CITY OF ALBUQUERQUE

**RE: Volcano Cliffs Subdivision Lot 1, Block 8, Unit 18
6512 Papagayo Rd. NW
Grading and Drainage Plan
Engineers Stamp Date 1/30/17 (D10D003O1)**

From: Rael, Rudy E. <RRael@cabq.gov>
Sent: Thursday, January 19, 2017 10:03 AM
To: Metro, Steven J.
Subject: 6512 Papagayo

Based upon the information provided in your submittal received 1/17/17, the above referenced Grading and Drainage plan dated 1/17/17 cannot be approved for Grading Permit until the following comments are addressed:

GRADING AND DRAINAGE PLAN
LOT 1, BLOCK 8, UNIT 18, VCS
ADDRESS: 6512 Papagayo Rd NW

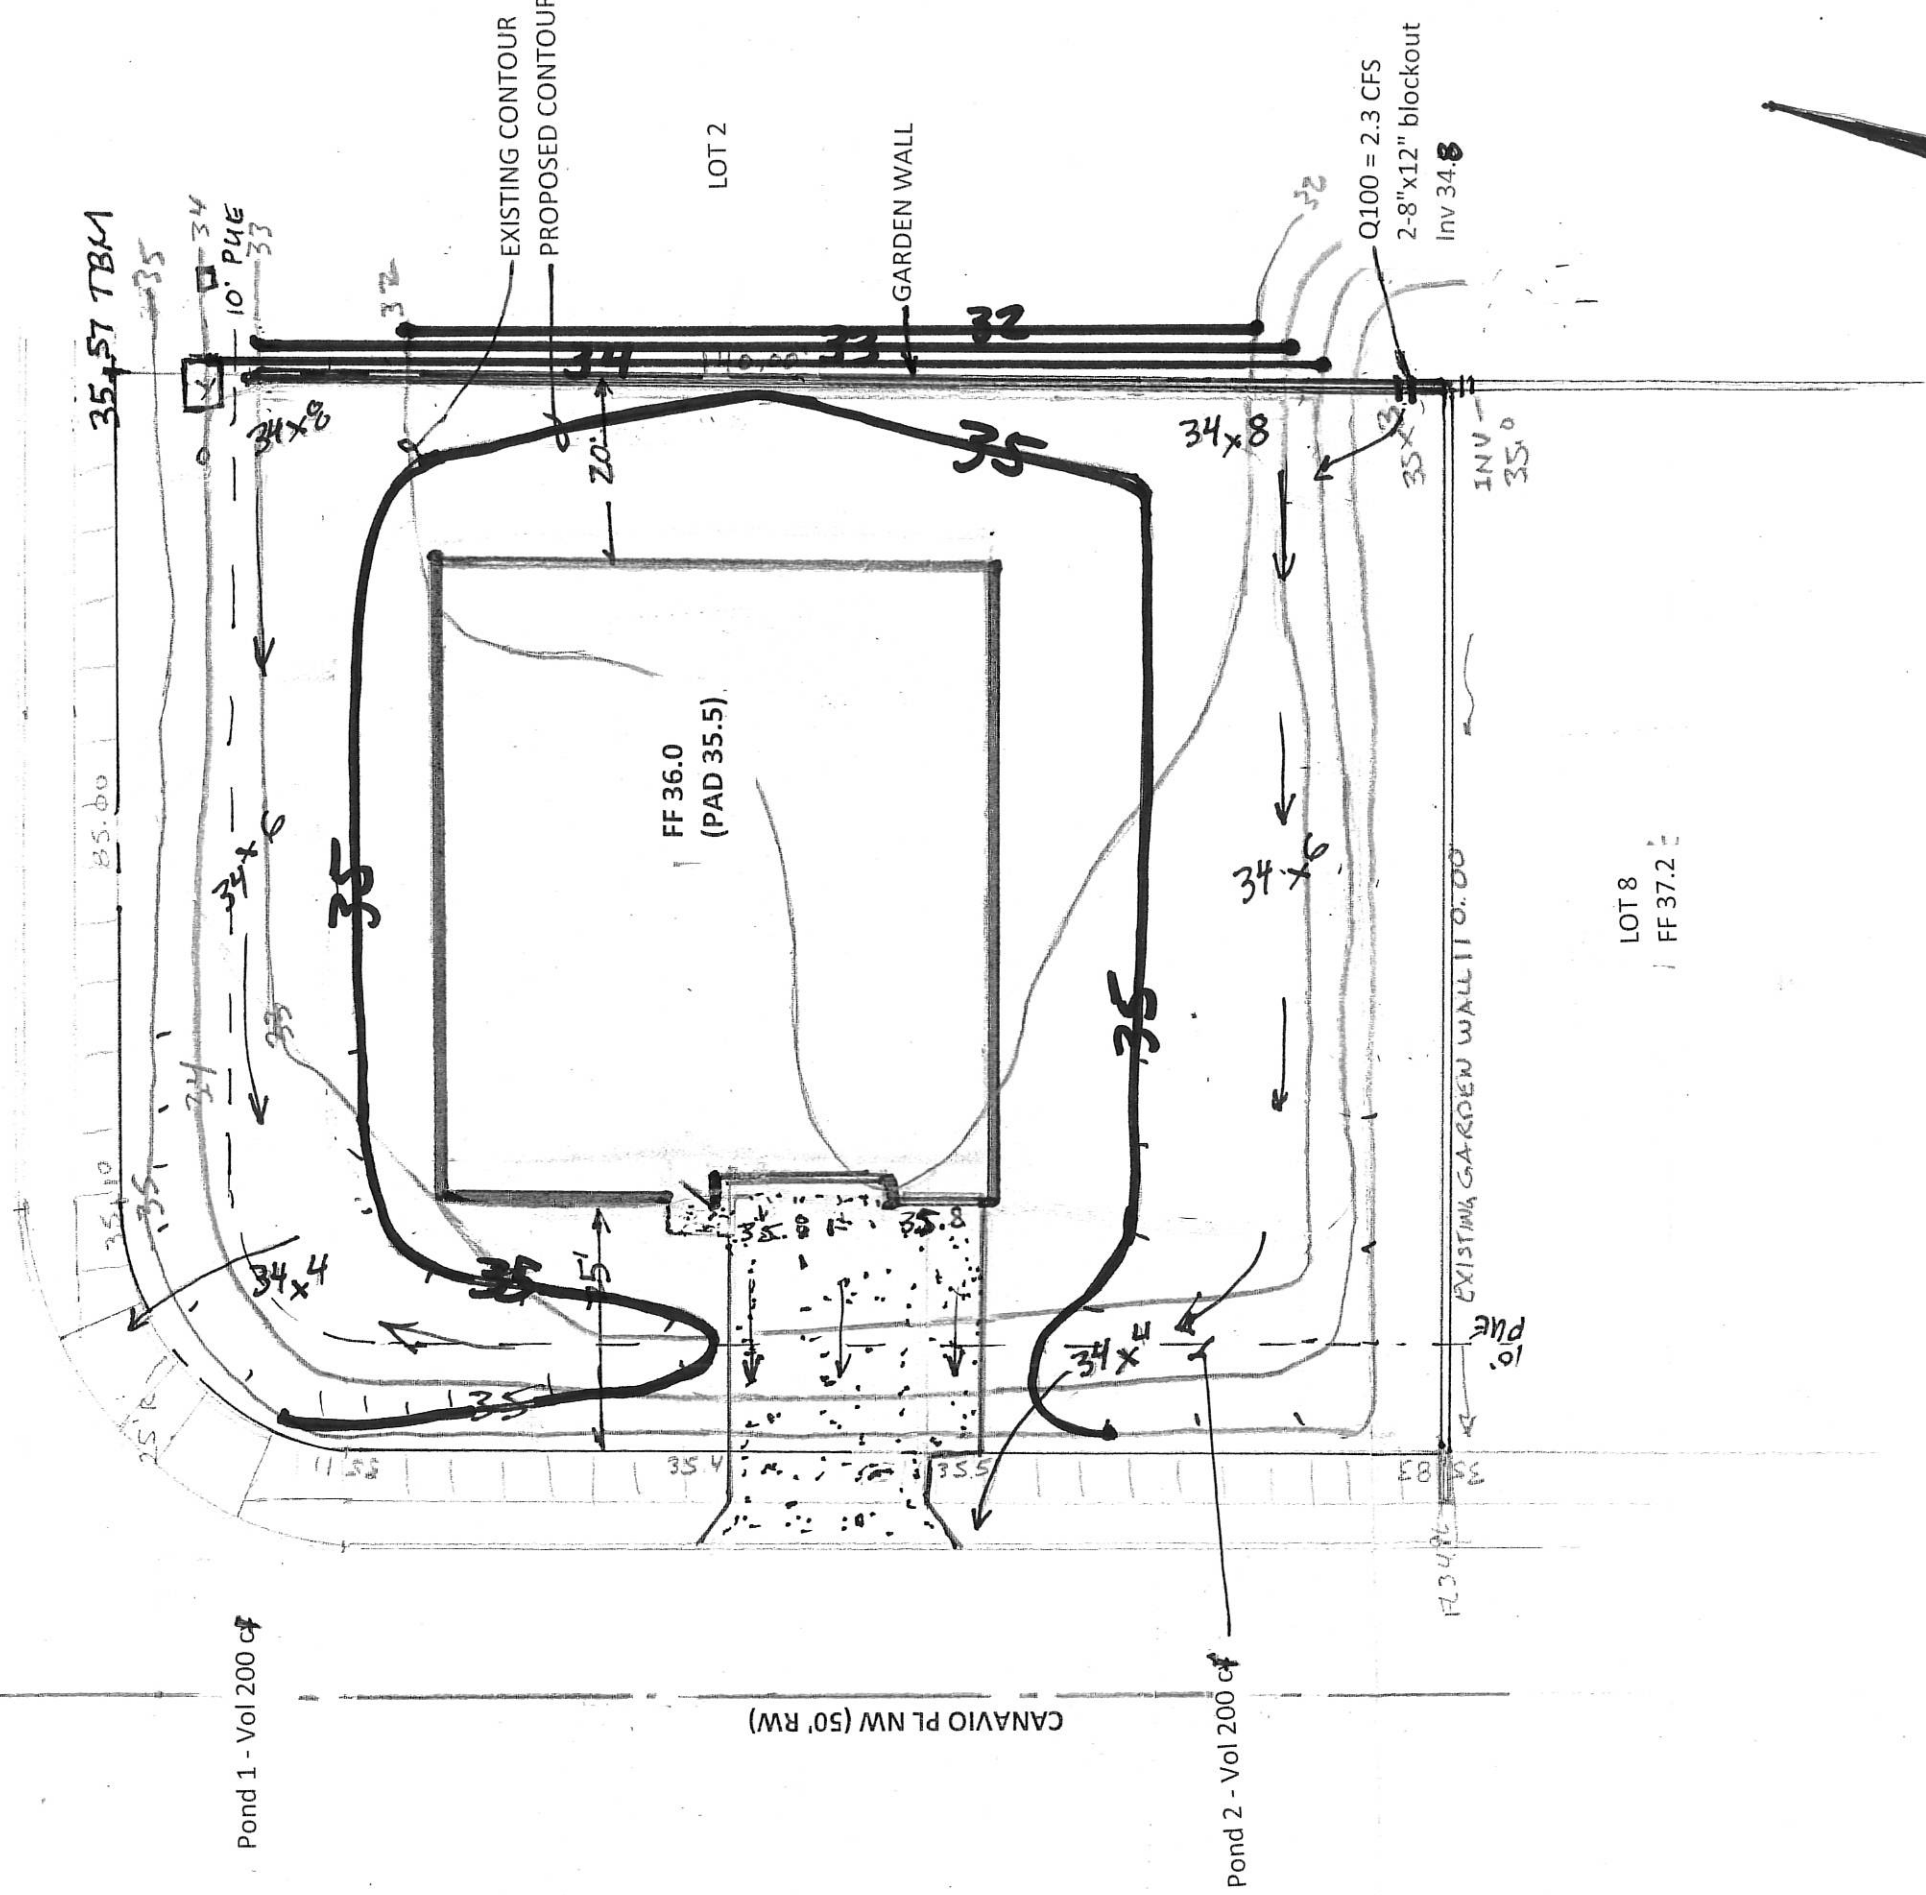
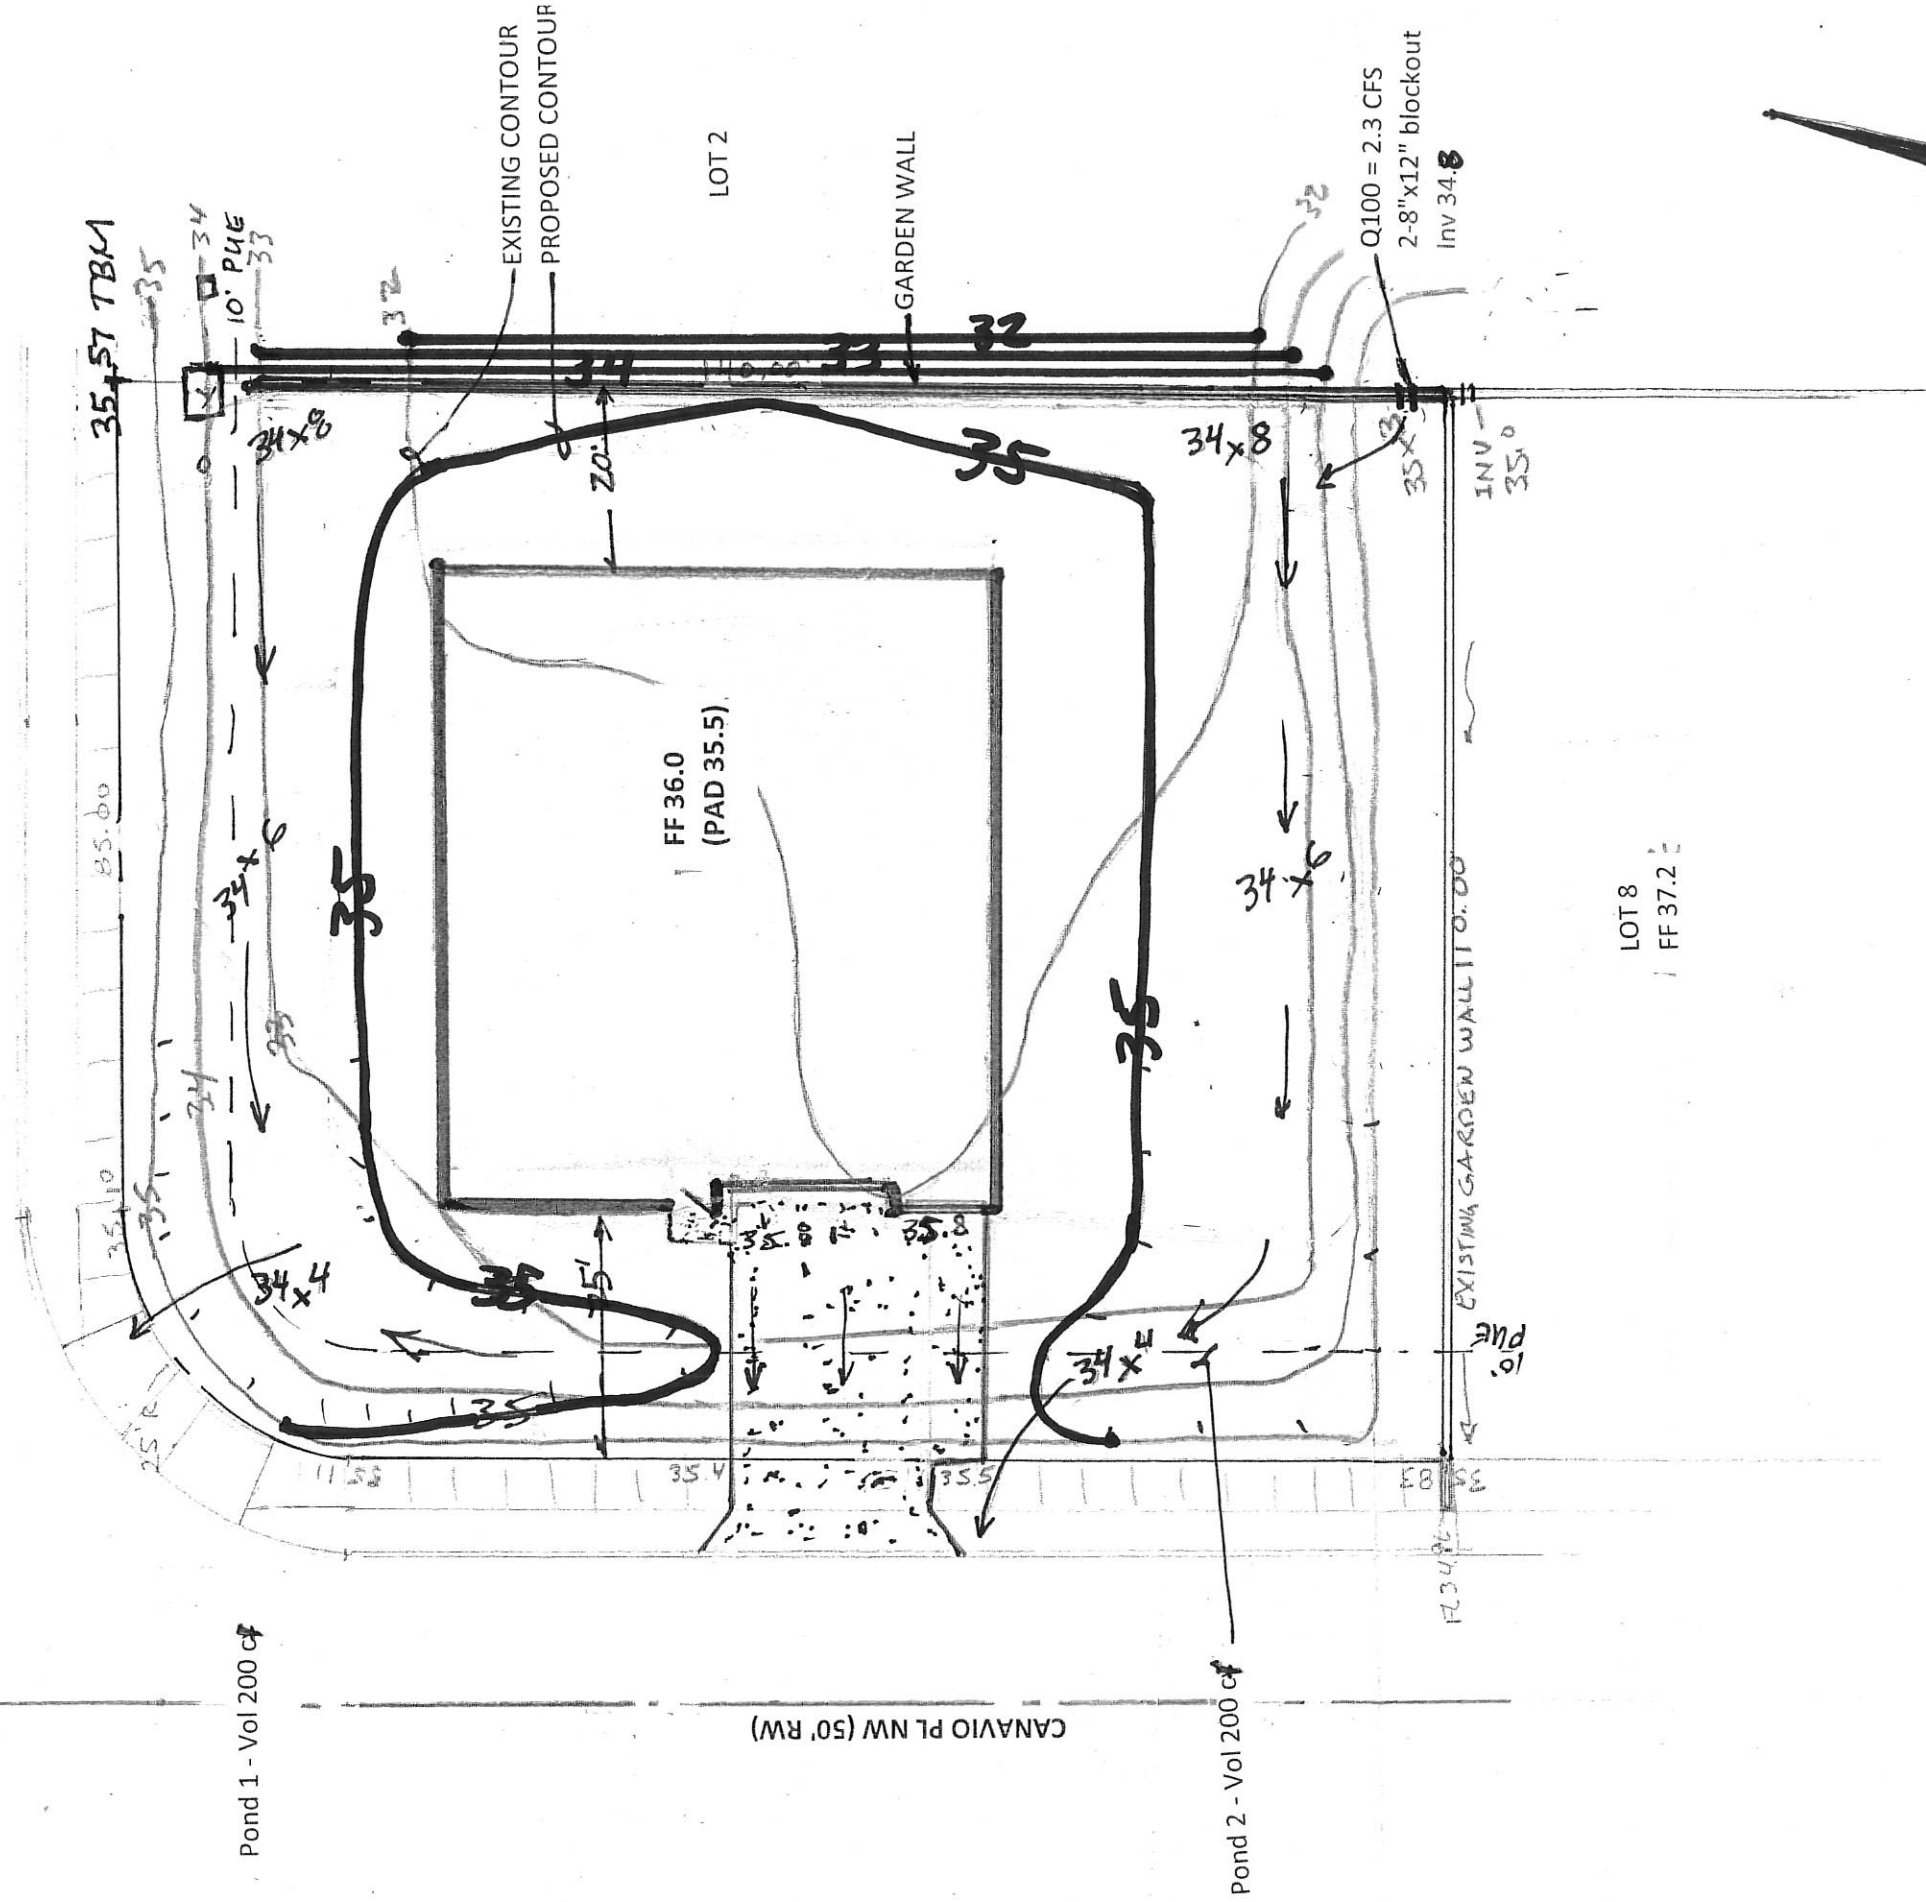
- Provide a note stating that future garden walls require a separate permit and this plan should be used for their placement.
- Also state that future garden walls require an opening 3" above grade in the SW corner.
- Provide a statement that a pad certification is required before a building permit is given.

- Note:
1. Future garden walls require a separate permit and this plan should be used for their placement.
 2. Future garden walls require an opening 3" above grade in the SW corner.
 3. A pad certification is required before a building permit is given.
